May 16, 2018

**RE: Primrose School
Grading Plan
Engineer's Stamp Date: 05/04/18
Hydrology File: C13D029**

Based upon the information provided in your resubmittal received 05/04/2018, the Grading Plan **is not** approved for Building Permit and Grading Permit. The following comments need to be addressed for approval of the above referenced project:

ENGINEER'S SEAL	PRIMROSE SCHOOL OF NW ALBUQUERQUE	DRAWN BY pm
	GRADING PLAN	DATE 3-20-18
		DRAWING
		SHEET # 4
		JOB # 2017092

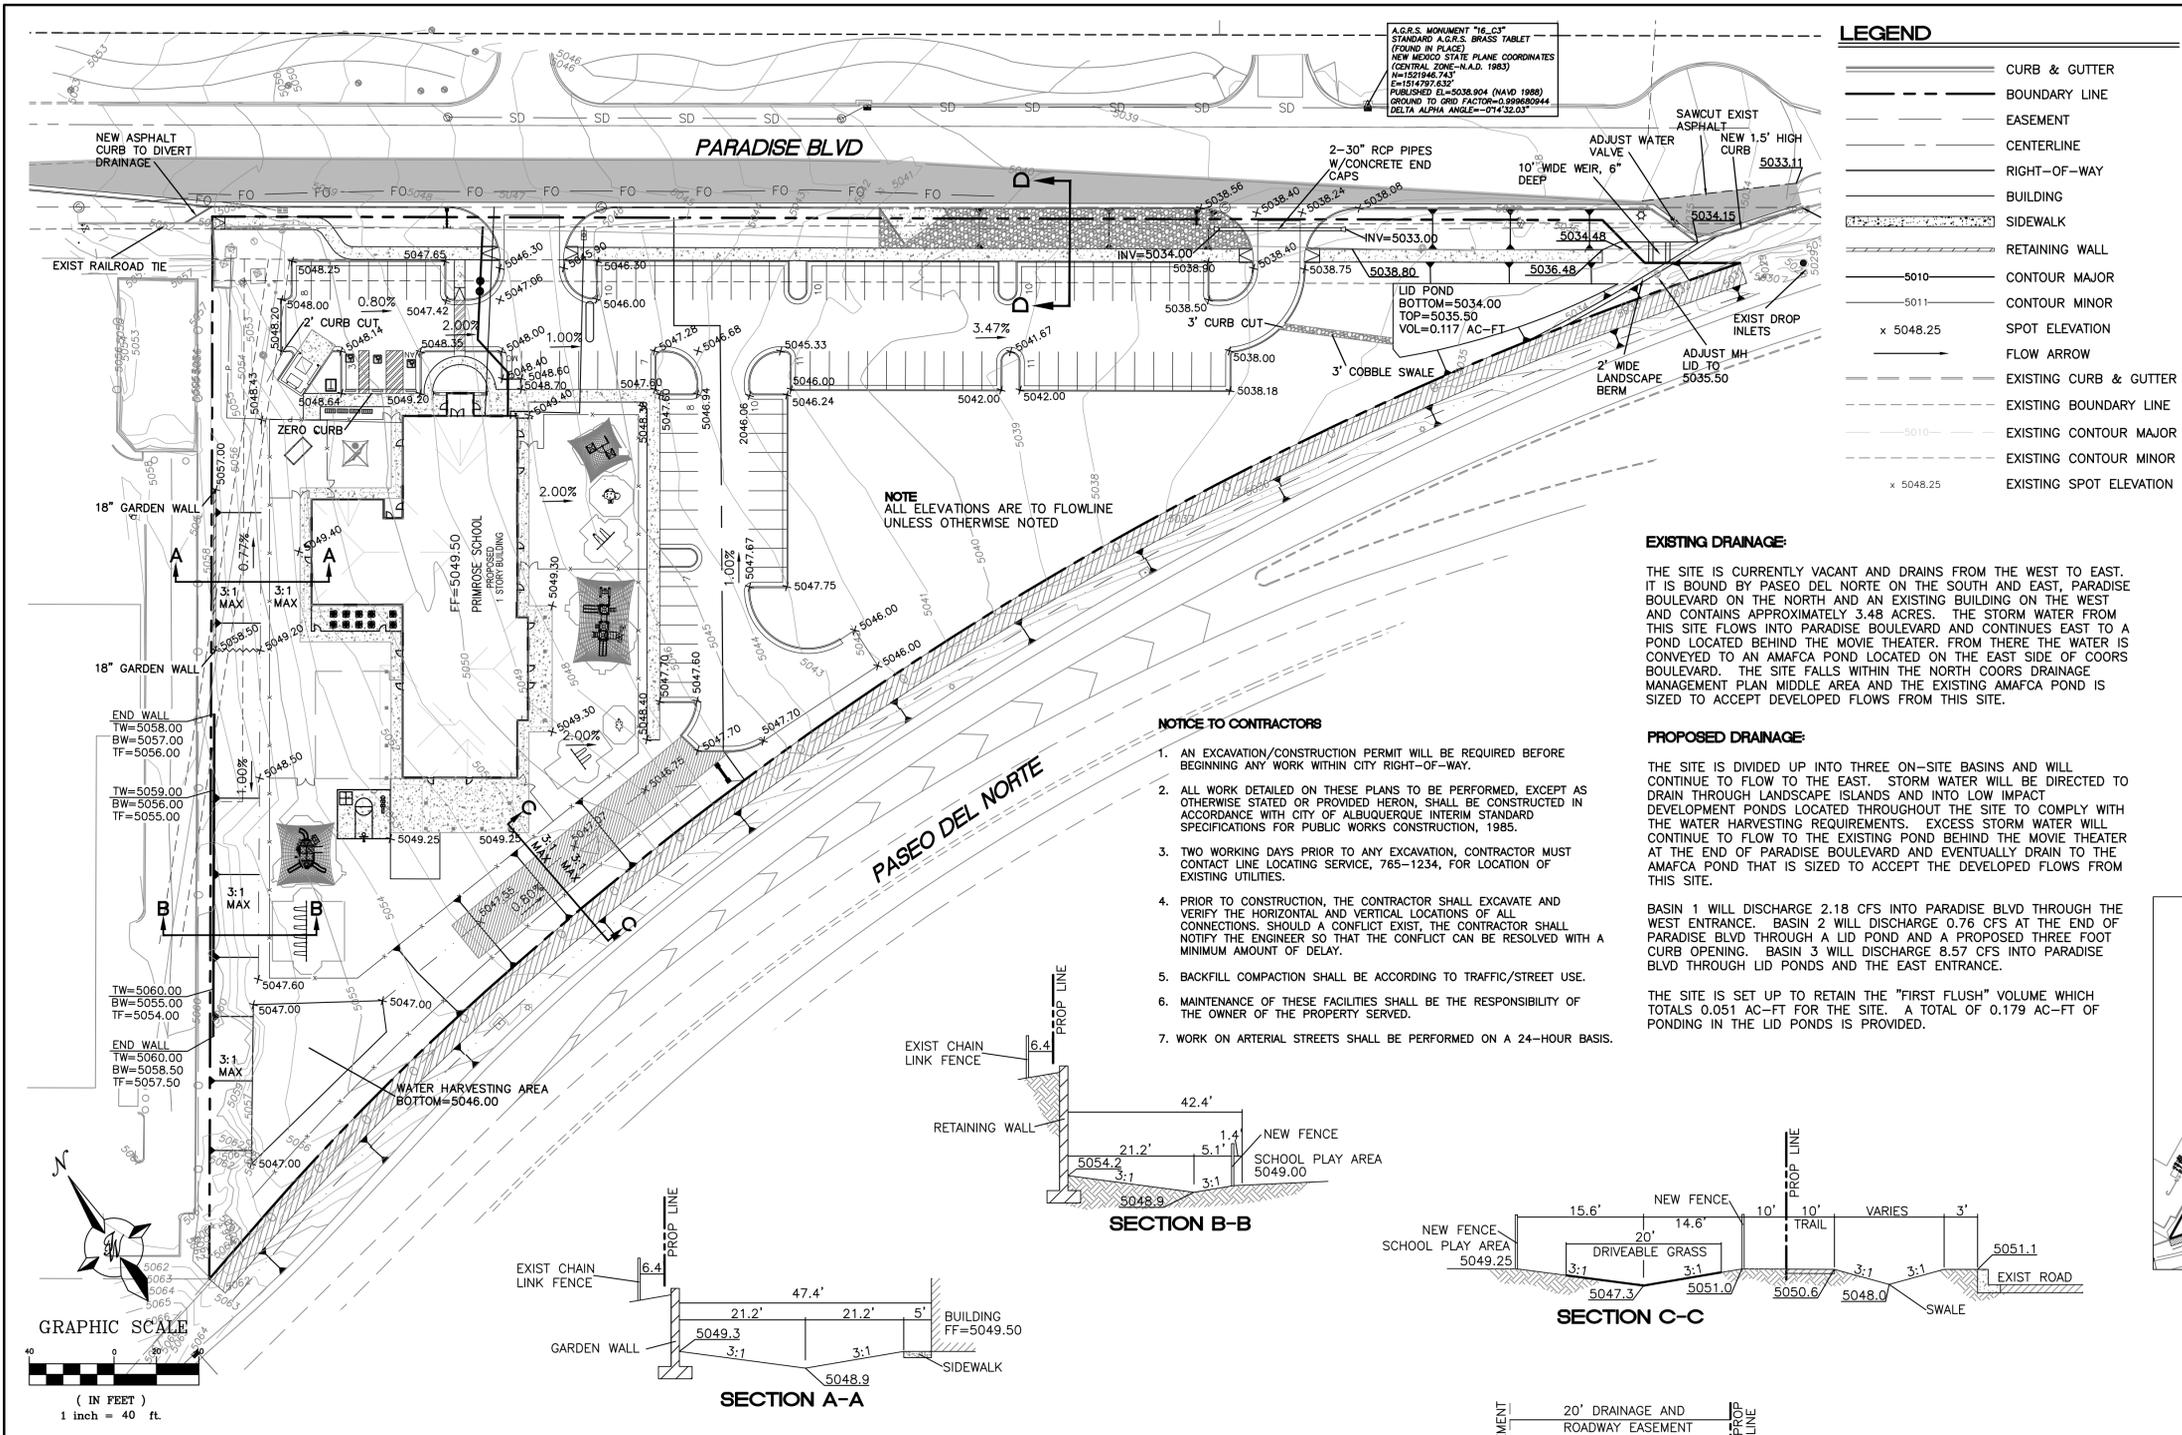
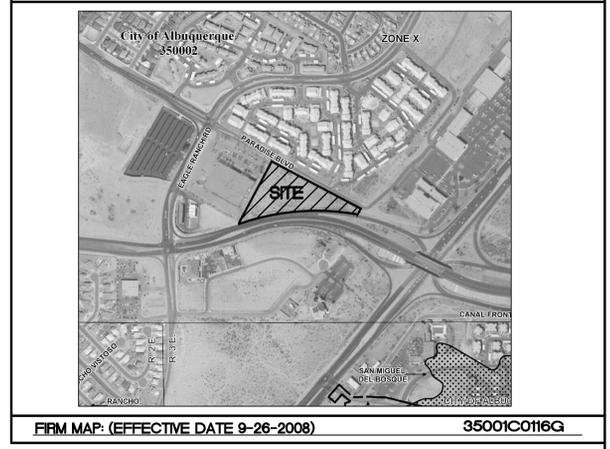
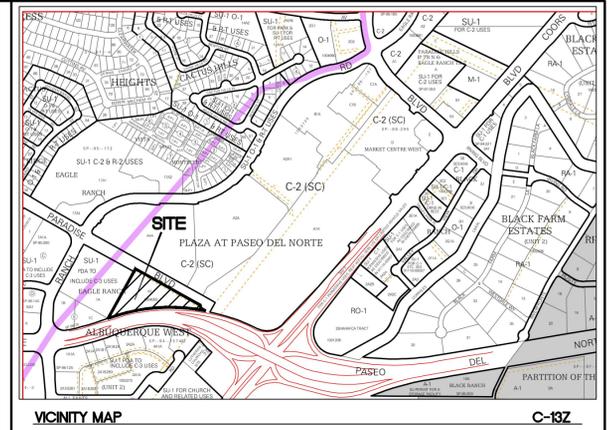
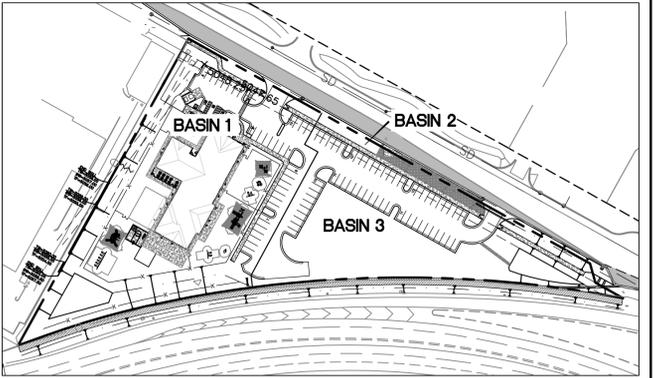
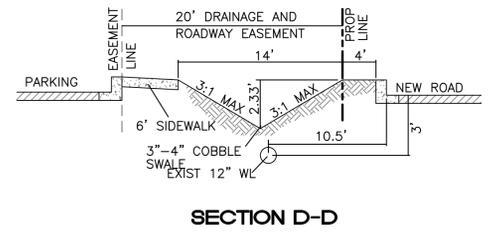
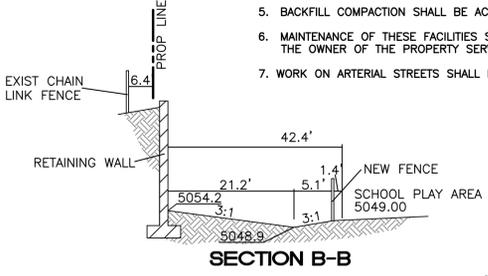
1. Please add the thickness and size of the riprap in the private cobble swale detail.
2. Please provide a detail of the 10' wide 6" deep weir at the LID pond outfall. Also please provide weir calculations for this 10' weir.
3. I noticed you have a curb and gutter transition for Transportation on Paradise Blvd. However the drainage from the church and drainage swale adjacent to the roadway has not been addressed with this proposed curb and gutter. The drainage will pond in front of the PNM transformer. This needs to be addressed somehow on the Grading Plan.
